SOUTHEASTERN SOIL & ENVIRONMENTAL ASSOCIATES, INC.

Revised lot 65 Forest Oaks.

PROPOSED SUBSURFACE WASTE DISPOSAL SYSTEM DETAIL SHEET

SUBDIVISION Forest Oaks LOT 65

Revised
SITE PLAN APPROVAL
DISTRICT BOARD USE SFD
7/12/15
ZONING ADMINISTRATOR
PR

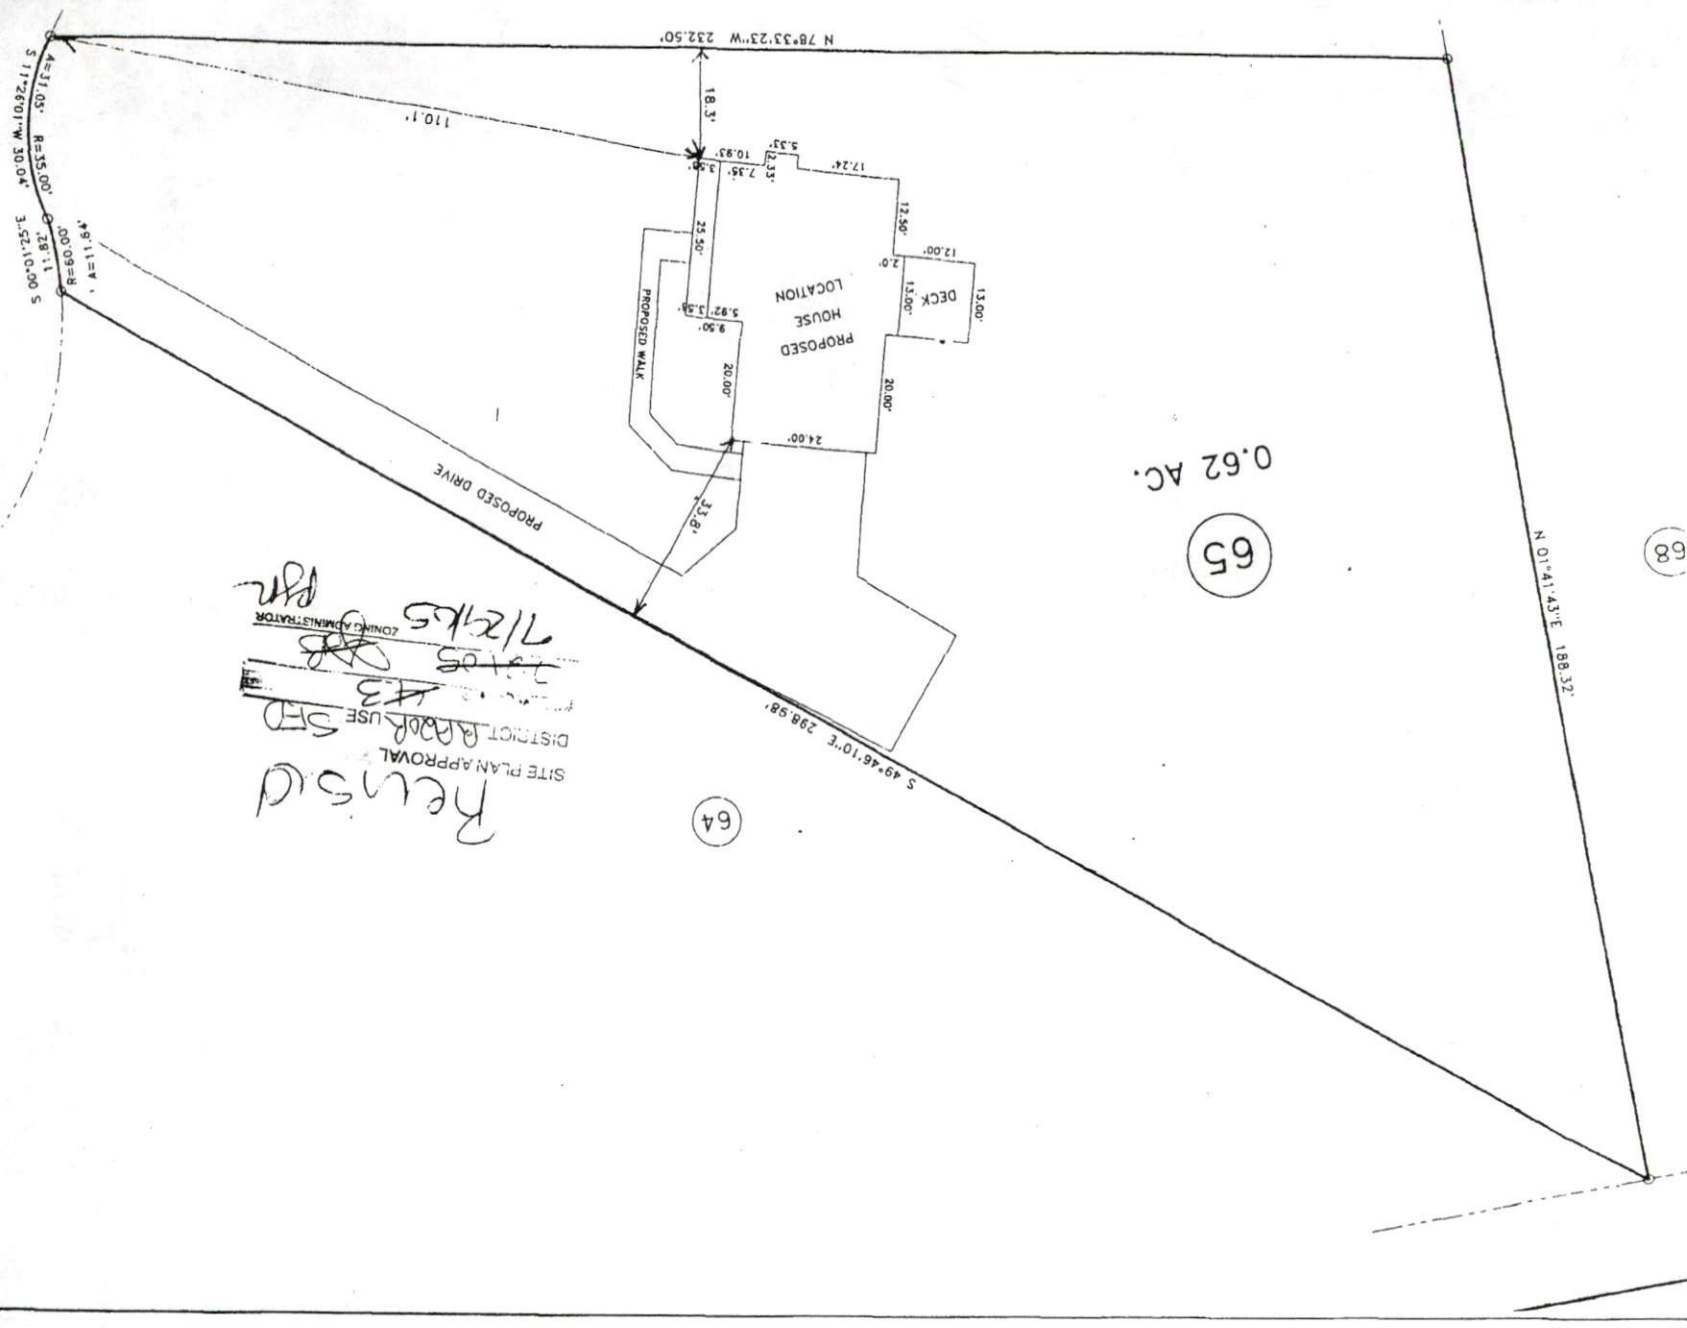
Front of site was graded & 4-6" of soil removed (note water meter + pine tree)

\* Now need to slide house 40' forward.  
see attached.

REAR OF HOUSE NEEDS TO SLIDE  $\approx$  40'  
toward road (from old layout)

Need French Drain along front and left side (facings)
